## DEVELOPMENT HEARING OFFICER

### Planning - Case Comments

**Project Number:** PR-2022-007682

**Project Name:** 622 15<sup>th</sup> St. NW

SKETCH PLAT OF
 LOTS 1-A, 2-A AND 3-A, BLOCK 32
 PEREA ADDITION
 (BEING A REPLAT OF LOTS 1,2,3 & 4, BLOCK 32)
 WITHIN SECTION 18, TOWNSHIP 10 NORTH,
 RANGE 3 EAST, N.M.P.M.
 TOWN OF ALBUQUERQUE GRANT
 CITY OF ALBUQUERQUE
 BERNALILLO COUNTY, NEW MEXICO
 SEPTEMBER 2022

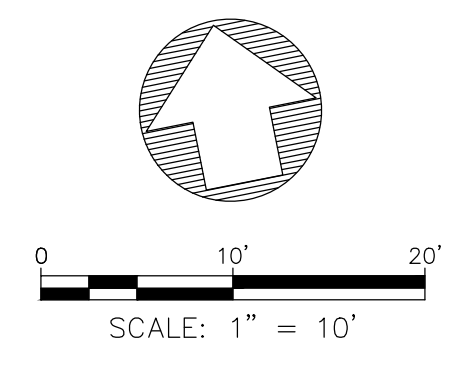
- *Clarify proposed parking spaces at existing triplex and provide parking calculations.*
- Per 5-4(E)(1)(c) In Areas of Consistency, alleys shall be included in subdivision design in those areas of the city where surrounding areas are platted with alleys and shall continue the alignments of those alleys.  
*Clarify how the alley is included in subdivision design.*

4. Please explain how the off-street parking for the existing Triplex will be provided. It appears insufficient, as there would be a minimum of 1 per Dwelling Unit, if 2 bedrooms or less.

5. Please show how you will be able to meet the required useable open space requirements of 500 square feet per dwelling unit for the existing Triplex on Lot 1-A, as per IDO 3-4(D)(2)(b)(1). This cannot include parking or vehicular use areas, or public right of way. This was previously nonconforming, but changing the lot size cannot increase the level of nonconformity, and it must come into conformance as per IDO 5-4(C)(1).

6. For proposed development on Lot 2-A, you will want to look at CPO-3, IDO 3-4(D)(5)(a)(1), Parking Location and Design, if there is an alley available it requires use of alley access and location of garages and parking at the rear of the property.
7. Code Enforcement has no further comments at this time about the proposed re-plat.
